**Re: Objection to MP08_0244 MOD 1 Modification Request for Mixed Used Development at 23-37
Lindfield Avenue and 11 Havilah Lane, Lindfield**

PCU041615

1 SHADOW DIAGRAM - 21stDEC_9AM
5003 SCALE1 : 650

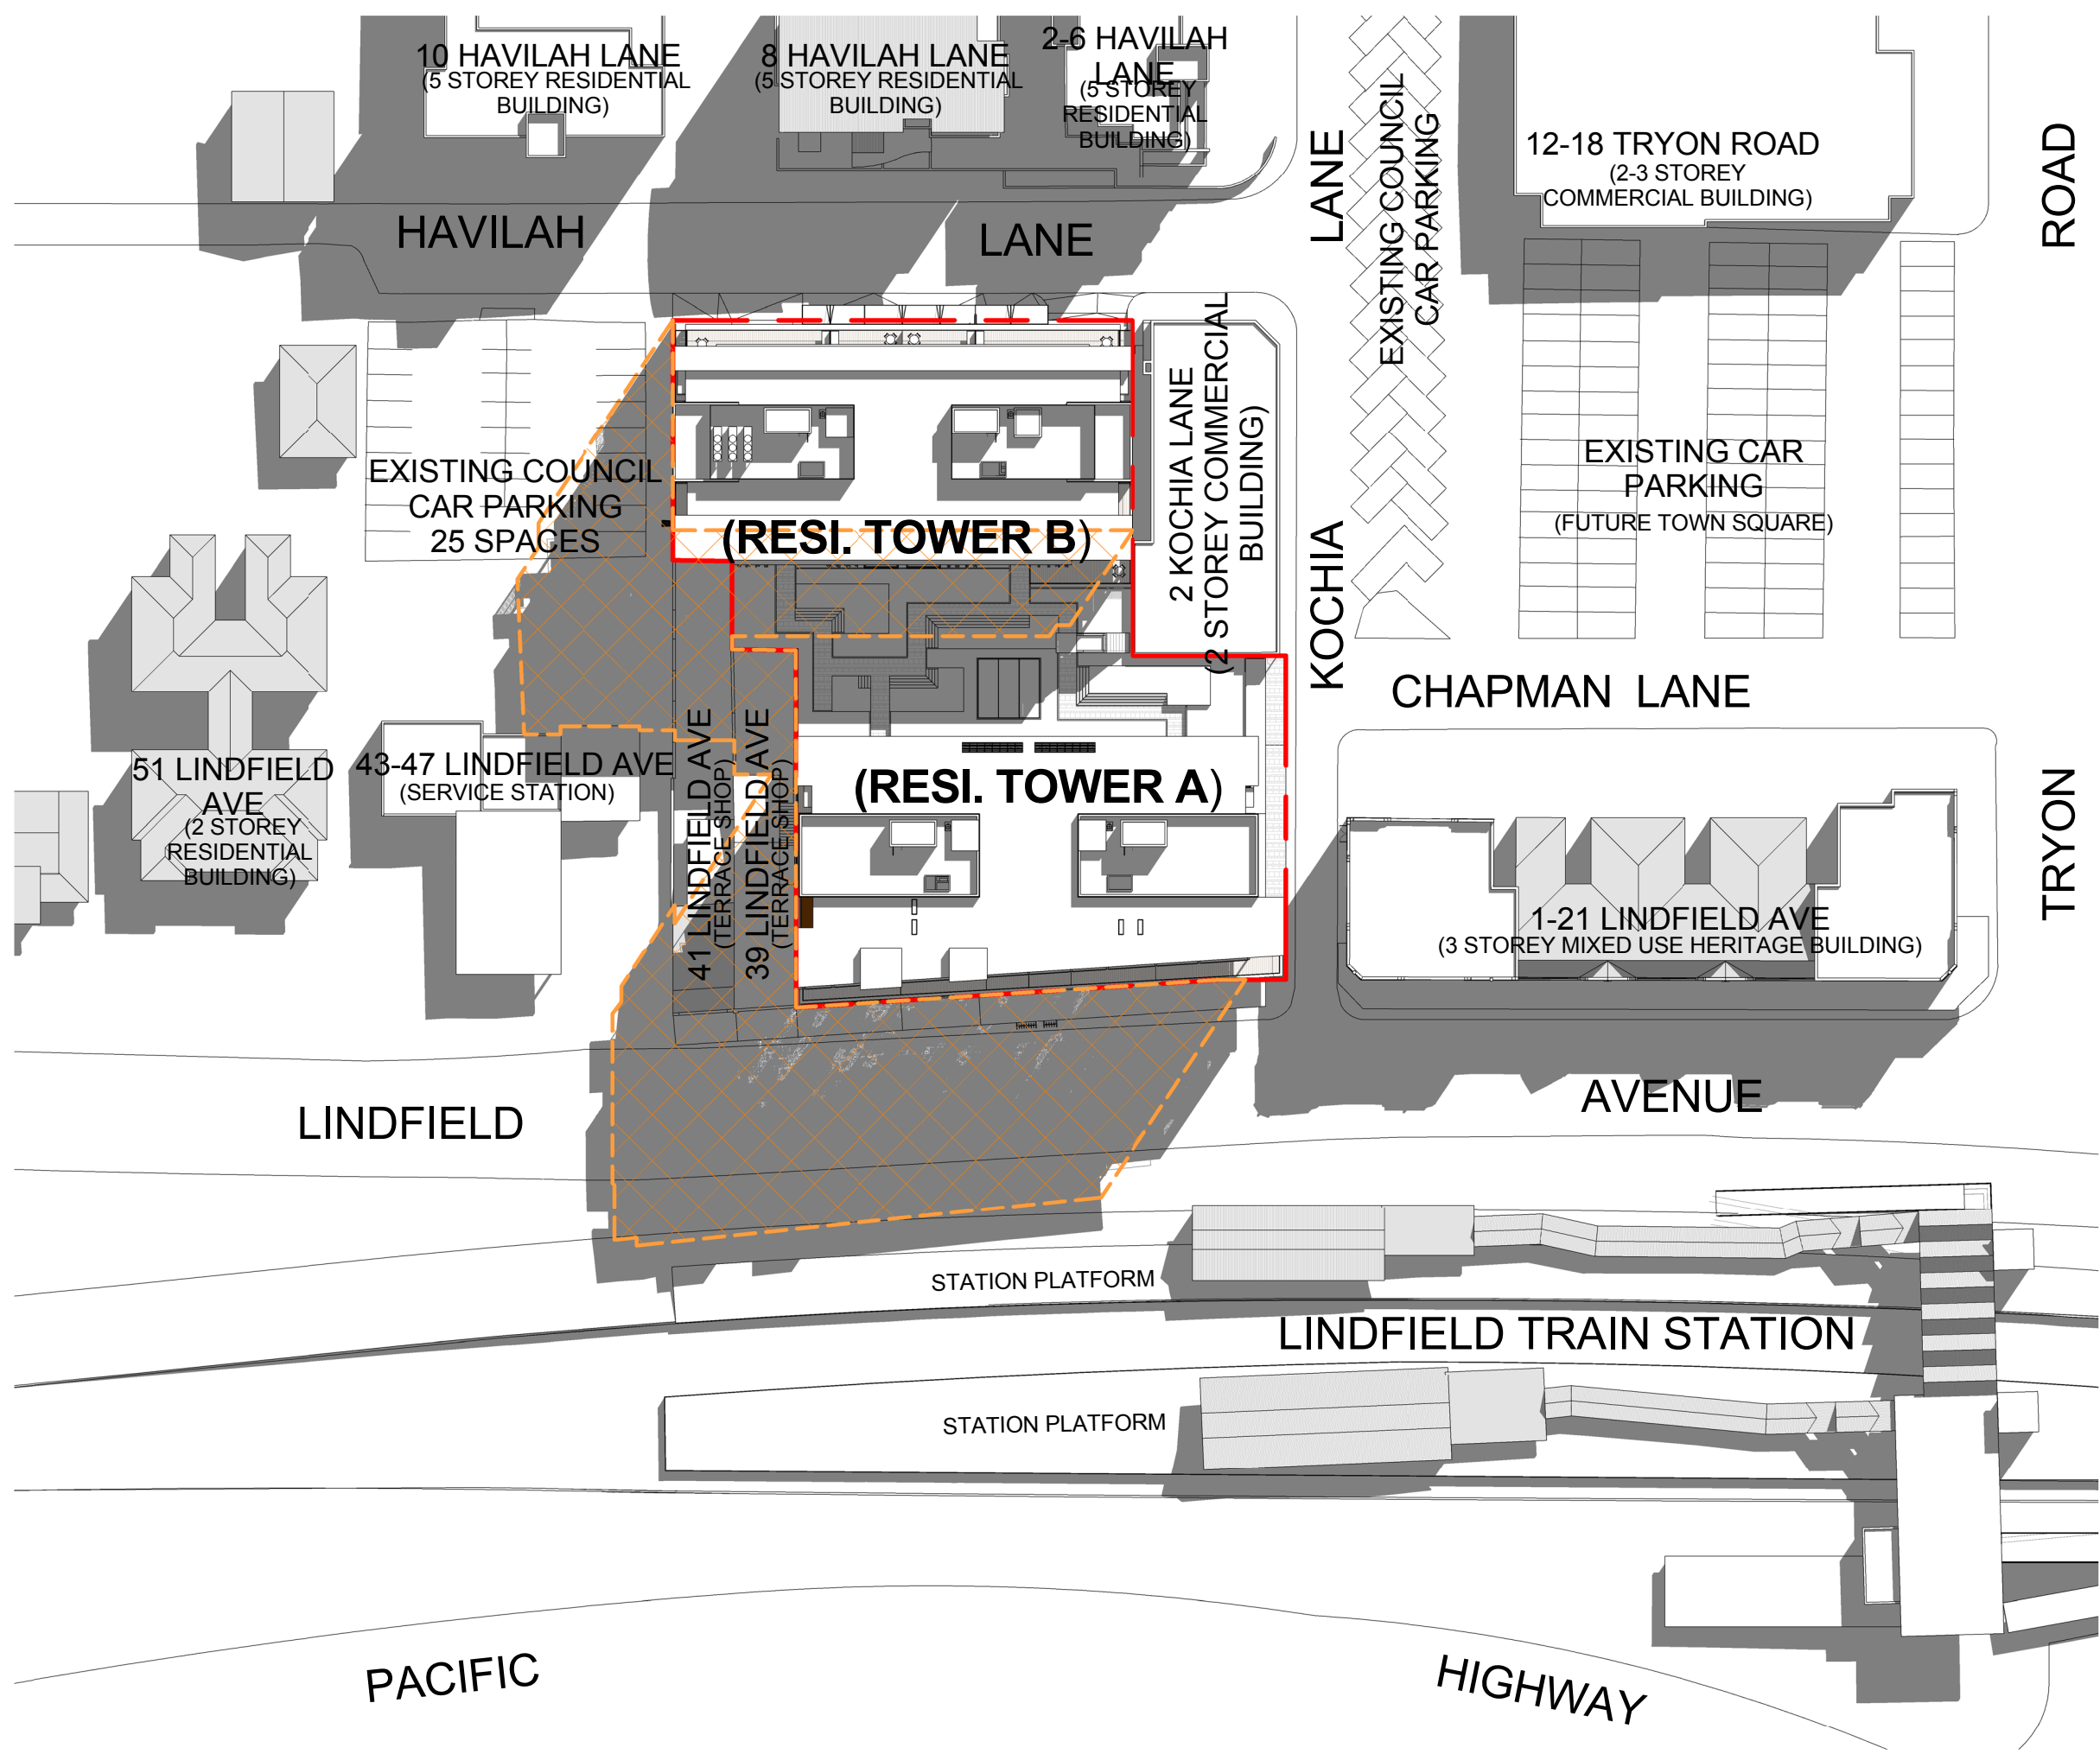
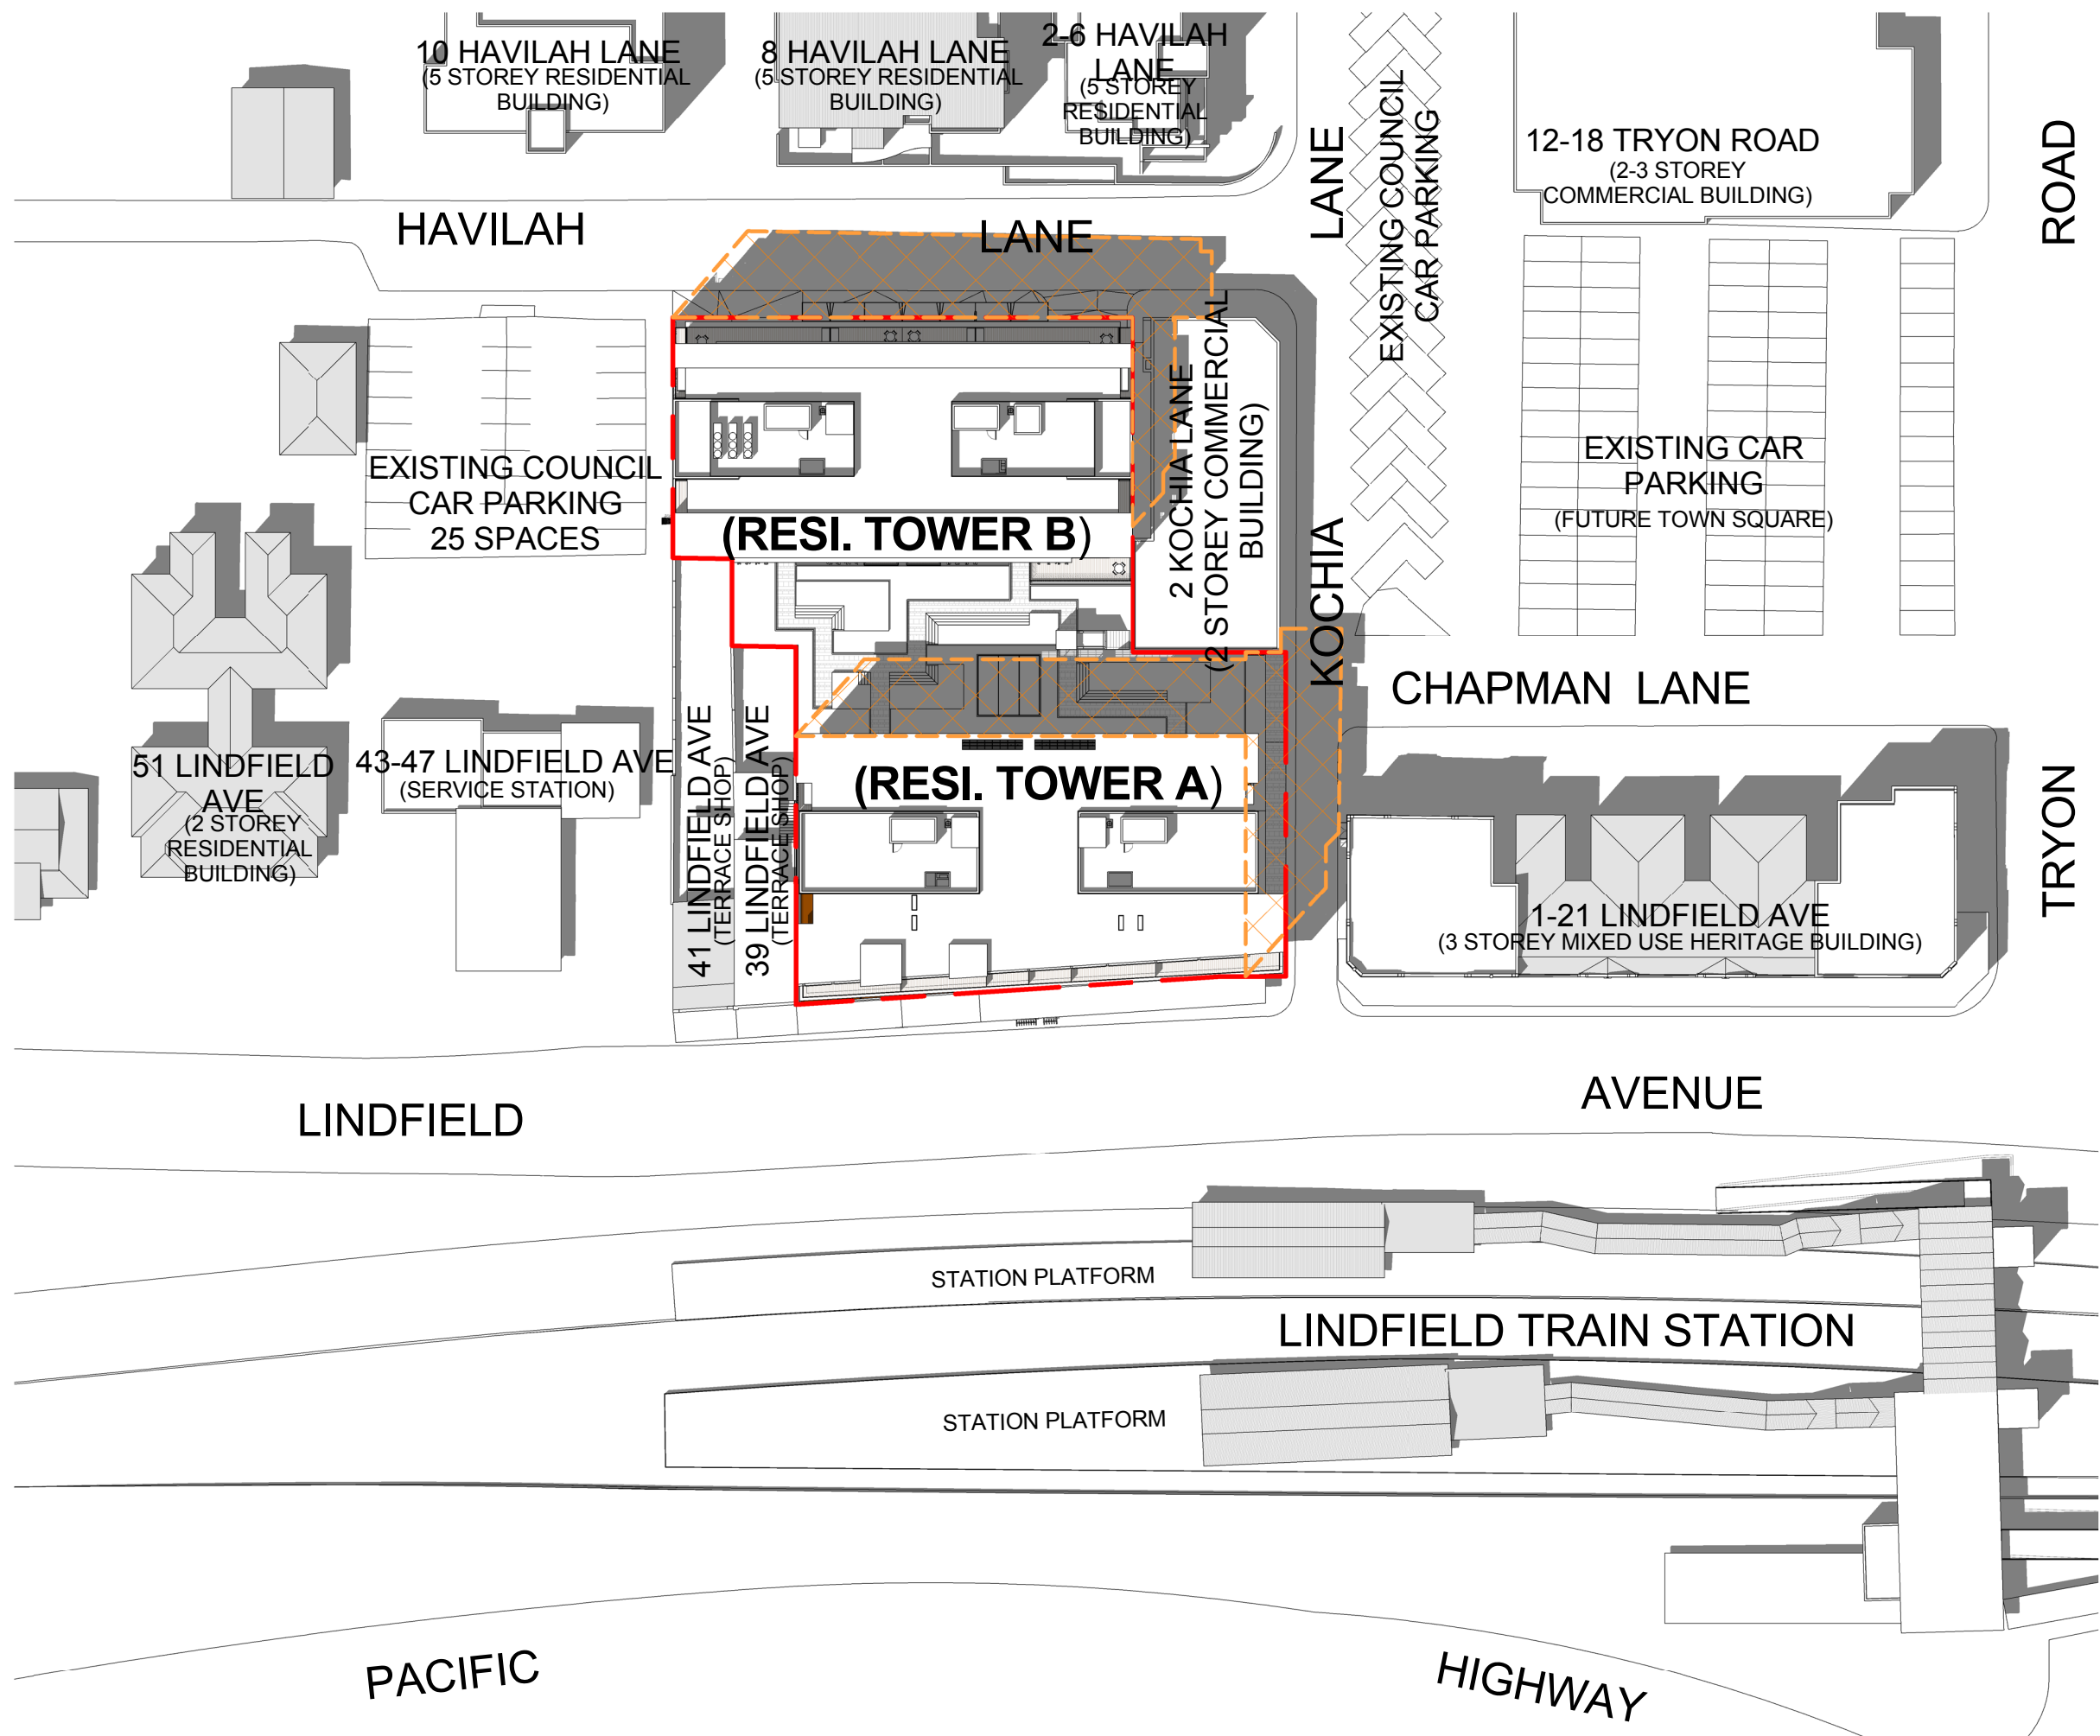
- The additional storeys create new adverse shadowing: a) for residents in the Havilah Lane apartments, particularly after 3pm b) for the popular outdoor café and central Lindfield hub area at 12 Tryon Road in afternoons, particularly in winter and c) for all commuters on the city bound Lindfield rail platform, instead of 50% of the year as approved, it will now be in shadow in the mornings 75% of the year
